Date: 15th January 2024  
Our Ref: PREAPP/23/00906

<b>PLANNING REFERENCE:</b>	PREAPP/23/00906
<b>DEVELOPMENT PROPOSED:</b>	Proposed rear and side extensions
<b>LOCATION:</b>	Bermuda, Hereford Road, Bayston Hill, Shrewsbury, Shropshire.
<b>PARISH/WARD</b>	BAYSTO/BHCS
<b>DATE RECEIVED</b>	8th November 2023

Drawing Title
Proposed Elevations

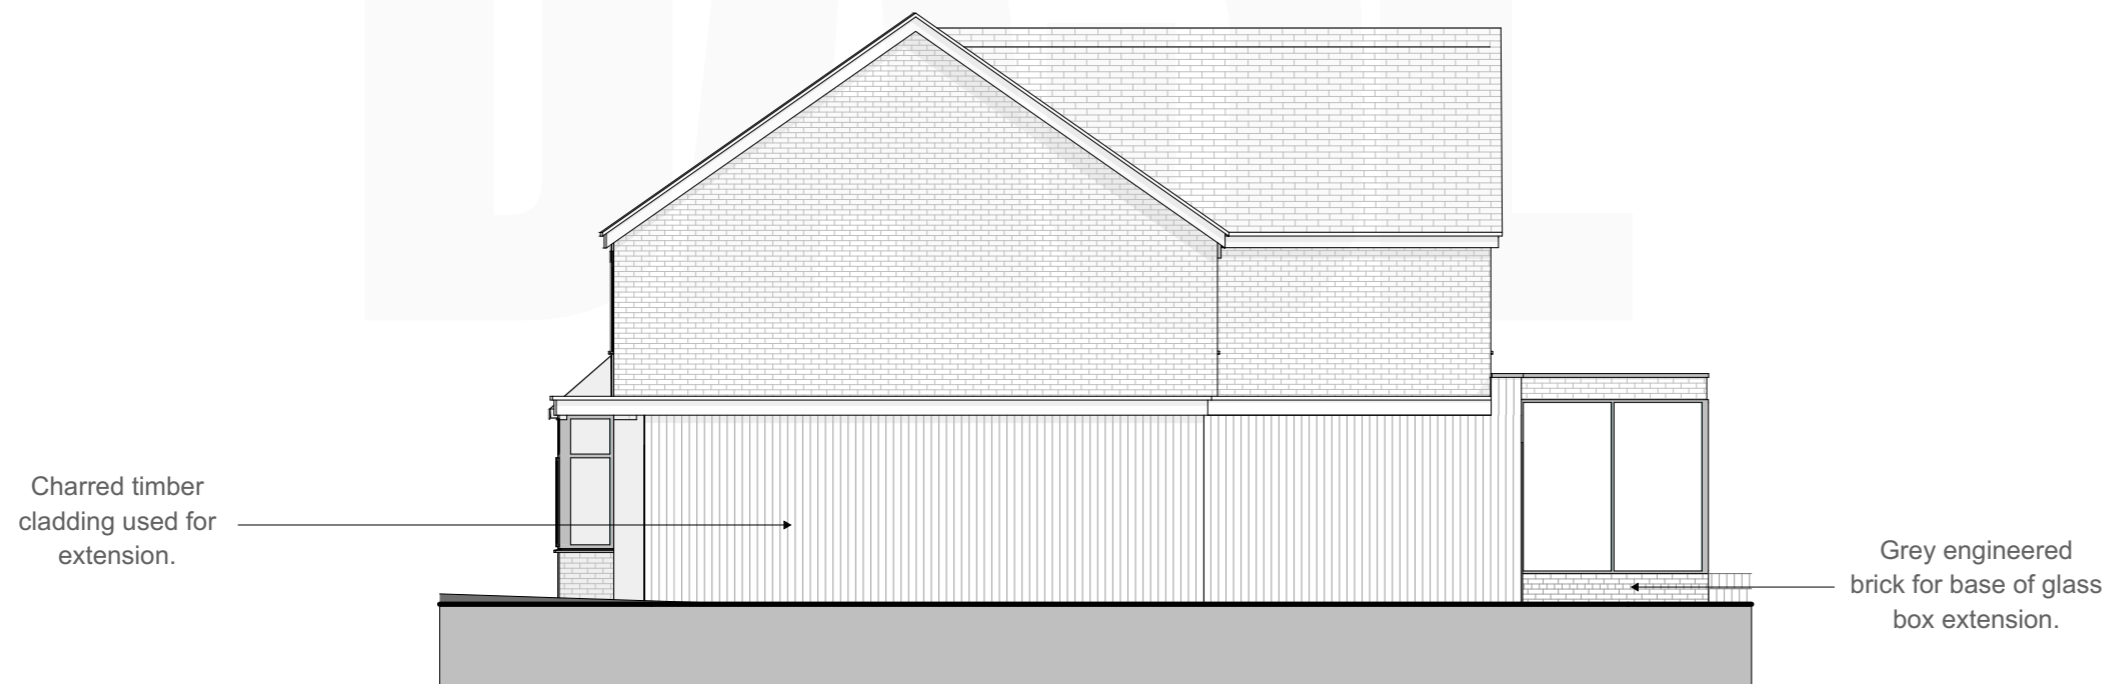
The scale, siting and materials of the extension are acceptable, the extension would sit right on the boundary of the neighbouring dwelling. The height of the extension is under 2metres, it would adjoin curtilage area with no overlooking windows and its southern position would not increase any overshadowing effects. The extension could be accommodated without reducing neighbour amenity.

The symmetry of the pair of extensions to the rear would be lost at ground level, the rear is generally only visible at first floor height from the surrounding area, where the symmetry would remain and as such the character and appearance of the area would be preserved. The materials are acceptable.

Drawing Title
 Proposed Ground Floor Plan

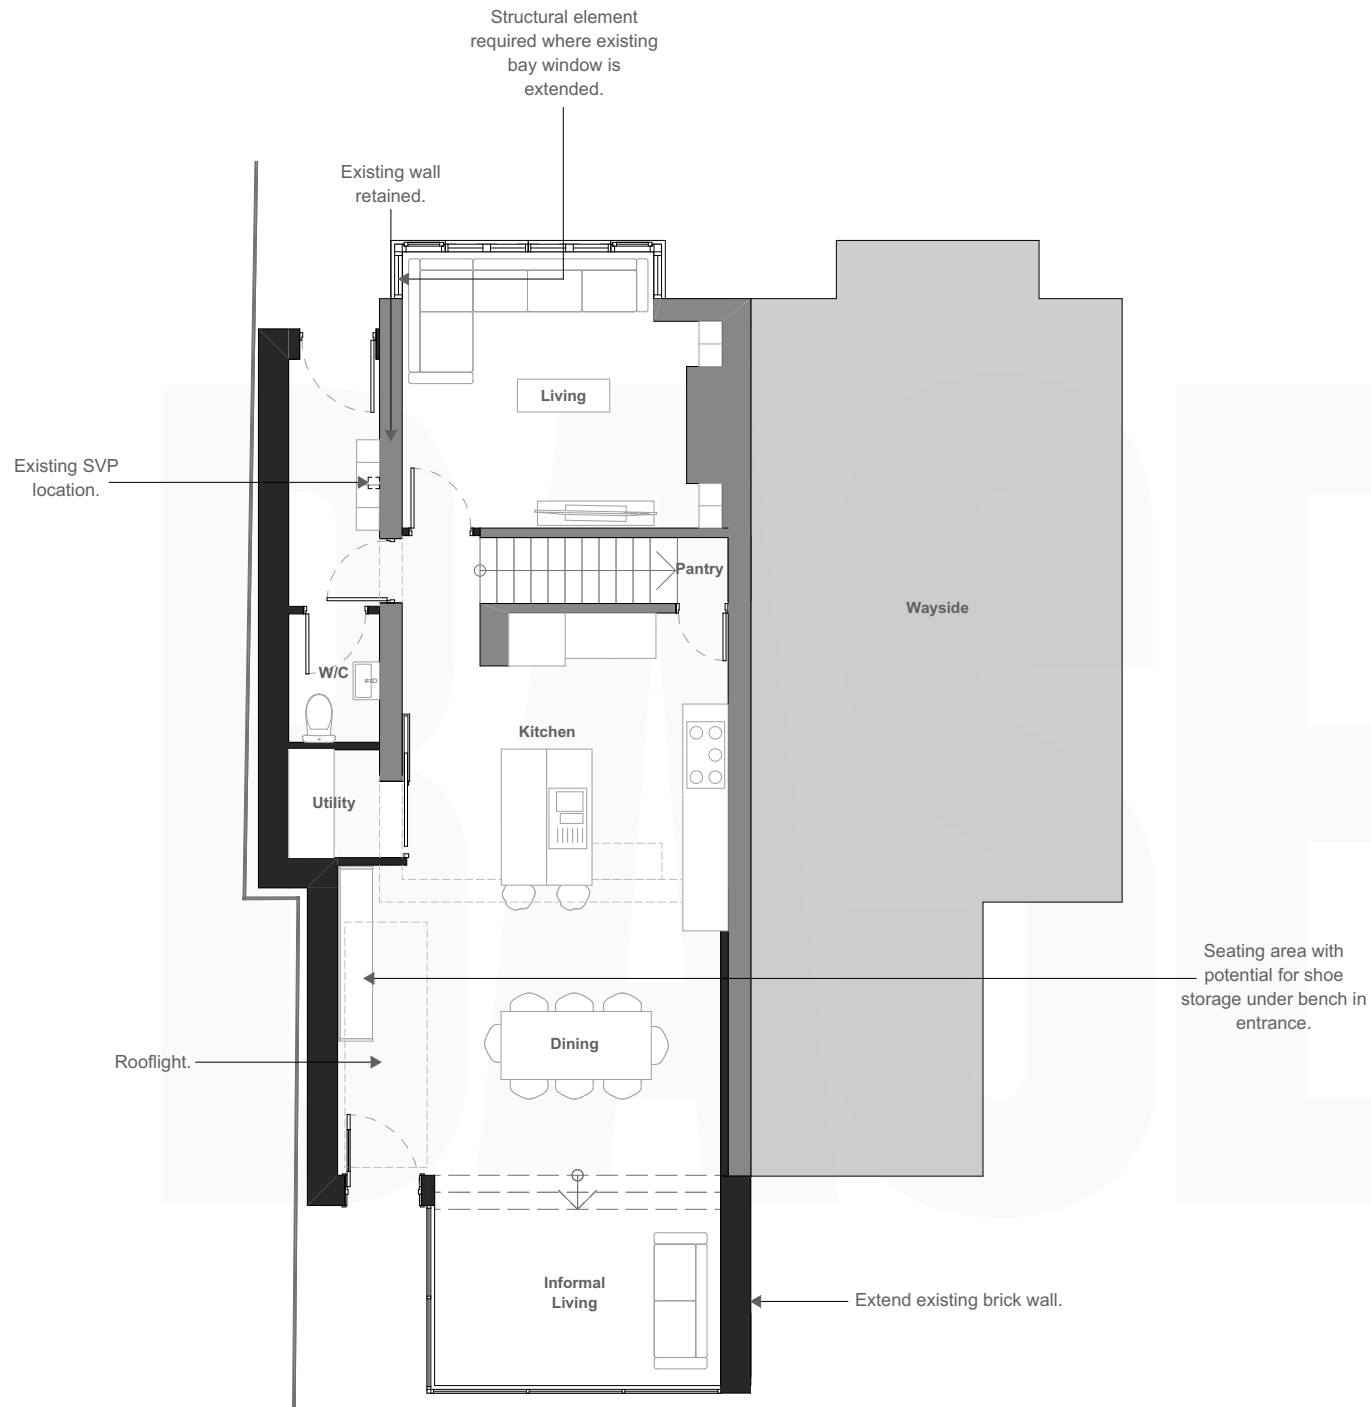
Its difficult to say conclusively whether the extension together with the existing garden room would cover 50% of the curtilage area, without measuring I would be inclined to say it doesn't and fulfils this criteria of the GDPO. The side extension appears to extend beyond the principle elevation of the dwelling and as such would not accord with condition (e) ii of the GDPO, planning consent would therefore need to be sought for the proposed extension. However, if the extension were stepped back from the front elevation of the dwelling, consent would not be required.
